NOTICE OF APPEAL

Re: Notice of Appeal - RZ-22-00005/CP-22-00005 Mardee Lake Determination of Non-Significance

Conservation Northwest and Karl Flaccus (co-appellants) submit this appeal of Kittitas County Community Development Services' Determination of Non-Significance (DNS) for the proposed rezoning of Mardee Lake from Forest and Range with a Rural Working Land Use to Rural Recreation Zoning and Land Use (RZ-22-00005). This appeal challenges the rezoning decision and SEPA DNS which we believe to be clearly erroneous and inconsistent with the County's own Comprehensive Plan, the County Code, SEPA, the Federal Endangered Species Act, and other applicable law. Please consider this appeal both as a SEPA appeal and to inform the Board of County Commissioner's decision on the proposal.

Figure 1. Mardee Lake Critical Area – Identified by Washington Department of Fish and Wildlife – Hashed Area is Priority Habitat and Species (PHS) mapped Biodiversity Area (Critical Area). Kittitas County adopted WDFW PHS when they updated their Critical Area Ordinance in February 2022.

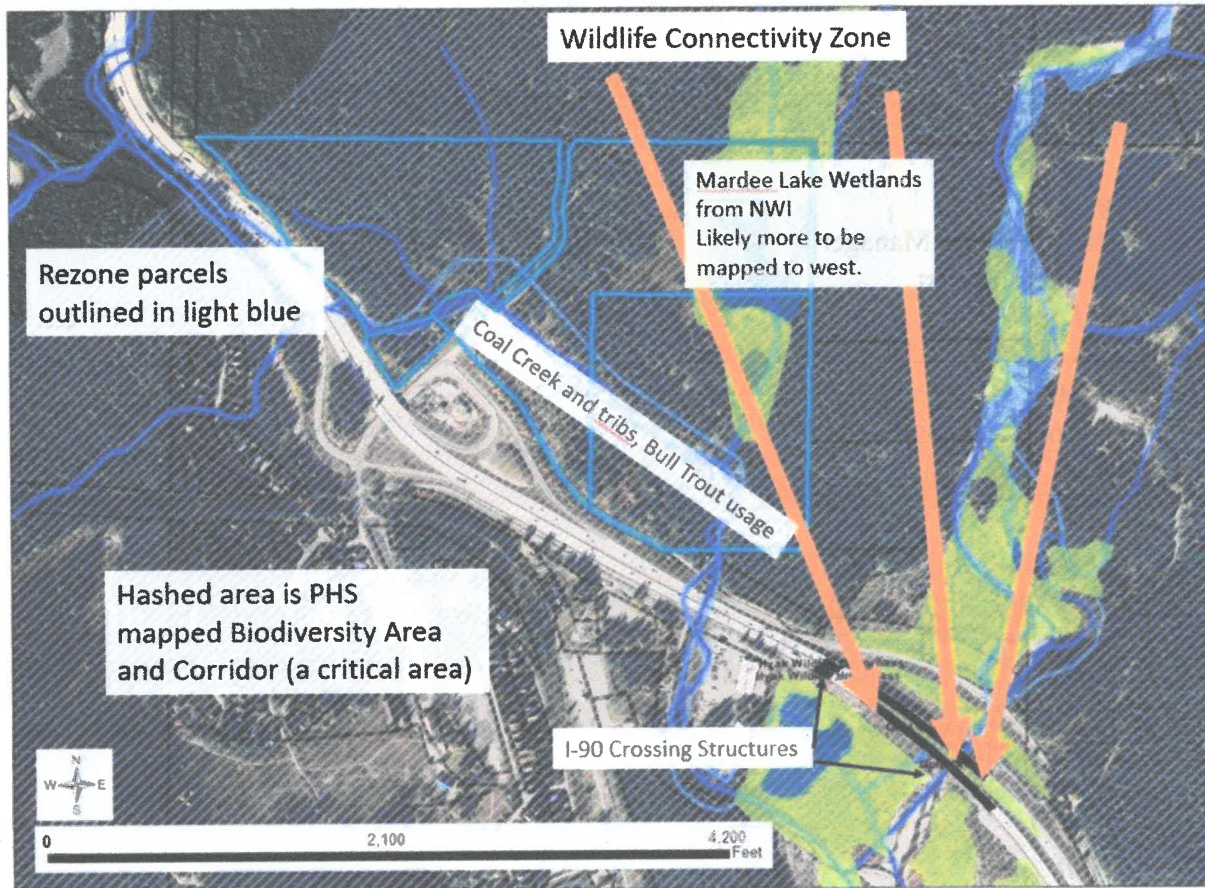
The Mardee Lake Inc. parcels contain multiple critical areas that support or have the potential to support a variety of species including Bull Trout, Westslope Cutthroat Trout, Gray Wolf, Marbled Murrelet, Northern Spotted Owl, and aquatic and terrestrial priority habitats including Freshwater Emergent Wetland, Freshwater Forestland/Shrub Wetland, and Biodiversity Areas and Corridor (see Figure 1. and the WDFW Priority Habitats and Species Report accompanying this appeal).

We do not believe that the DNS adequately considered WDFW PHS Critical Areas, and the wildlife connectivity corridor critical area in particular, and is therefore inconsistent with the Kittitas County Comprehensive Plan and the county’s Critical Areas Ordinance.

Based on the above, we believe the DNS issued for this application is not sufficient to adequately address potential adverse impacts to critical areas, including a wildlife connectivity zone.

Co-Appellants Conservation Northwest and Karl Flaccus seek invalidation of the DNS and direction to the Director to prepare a Critical Areas Report, Determination of Significance (DS) and associated Environmental Impact Statement (EIS).

A Critical Areas report would more accurately identify the extent of critical areas (streams, wetlands, species habitat, and connectivity corridor), address potential impacts in or adjacent to the critical areas from future development, and how the proposed application proposes to avoid
